POST SUBMISSION ADVICE FROM OFFICERS

From: [Emma Lancaster](#)
To: [Caroline Ford](#)
Cc: [Johnathan Welton](#); [Kelvin Pearce \(kelvinpearce@albionland.co.uk\)](mailto:kelvinpearce@albionland.co.uk); [Chris Smith \(chris.smith@cornisharchitects.com\)](#)
Subject: RE: 21/03177/F - Axis J9 Phase 3, Howes Lane, Bicester
Date: 02 March 2022 16:31:00

From: Caroline Ford <Caroline.Ford@Cherwell-DC.gov.uk>
Sent: 18 February 2022 17:35
To: Emma Lancaster <emma.lancaster@quod.com>
Cc: Johnathan Welton <johnathan.welton@quod.com>
Subject: 21/03177/F - Axis J9 Phase 3, Howes Lane, Bicester

Fig. 15 Unit 4 Elevations

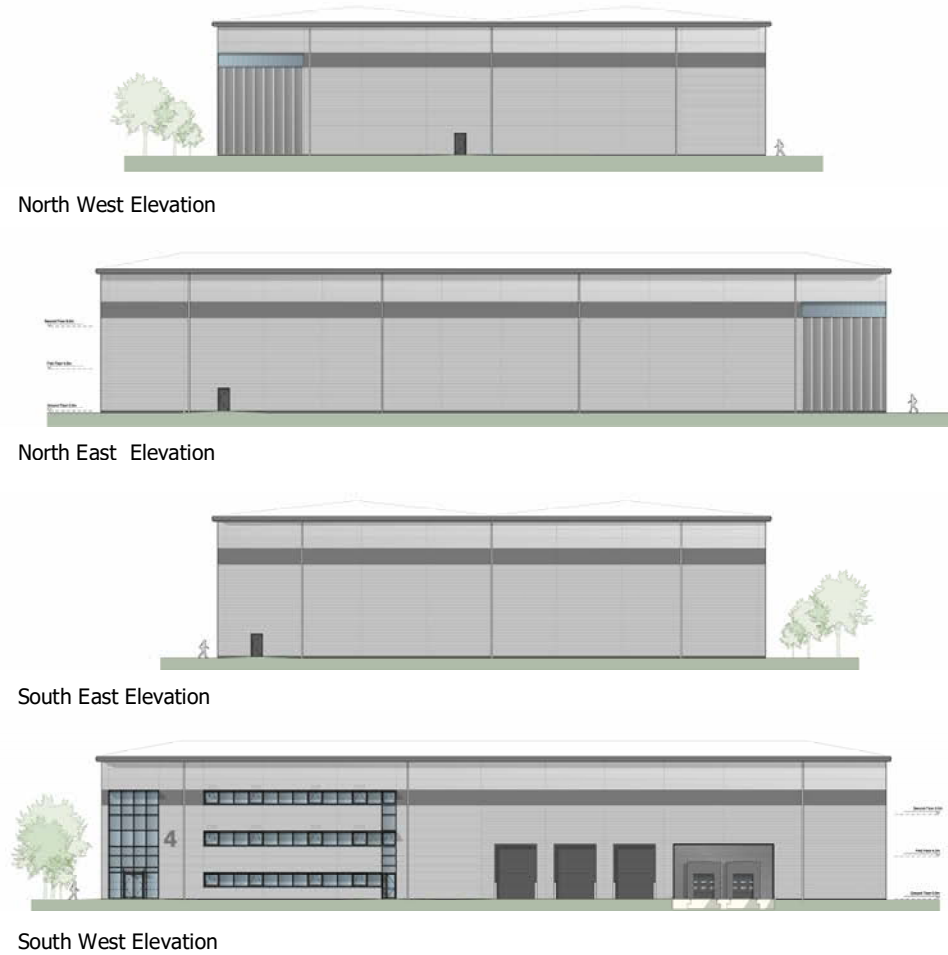
- I wonder if the north east elevations of unit 4 could be activated further (perhaps in a similar way to unit 5) bearing in mind a road located to the north of this unit and its prominence when viewed from the north in the future.

Fig. 17 Units 6-10 Elevations

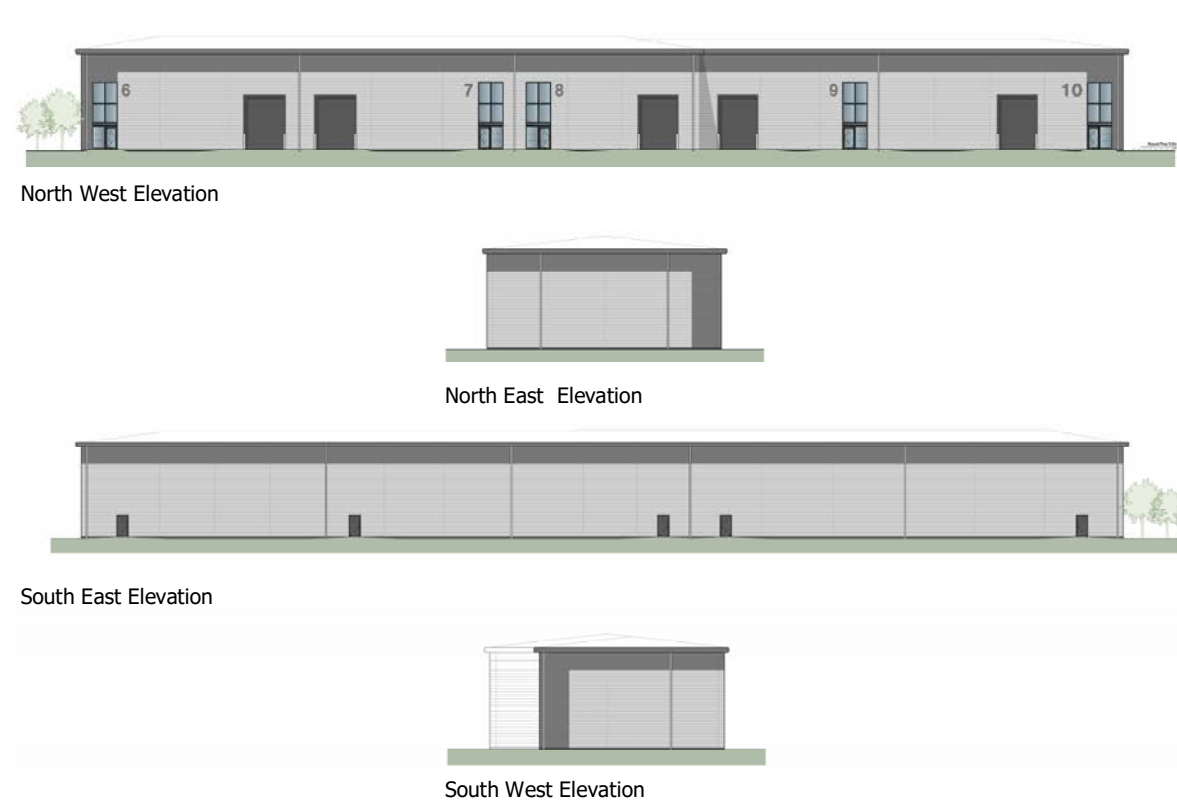
As well as the arrangement of units 6-10, I am afraid that the arrangement of unit 11 is also unacceptable with the rear of the unit facing south. This will be one of the most visible and prominent elevations of any of the proposed buildings and the rear of a building in such a prominent position would be unacceptable. I would suggest that this building be re-orientated so that its rear is east facing with its front and sides activated to provide a more appropriate arrangement to the street scene.

- Units 6-10 should be elevated further in design terms. Whilst I accept that they follow a similar design approach to the existing small units already constructed, these units are far more prominent and the lack of activation and interest is unacceptable where they would be such a prominent part of the street scene along the future strategic road. Please can you also consider the orientation of the roof arrangement and ensure this is optimum for solar panels, which currently appear to be positioned such that they are eastward facing. Perhaps a consideration of roof form to enable more south facing slopes to optimise the opportunities for PV could also be part of the solution to add interest to these units.

- I have already commented upon the orientation of unit 11 (above) but would also emphasise the point that in a similar way to units 6-10, this unit also needs to be improved in terms of its activation/ interest to provide for a more appropriately designed unit in such a prominent position.
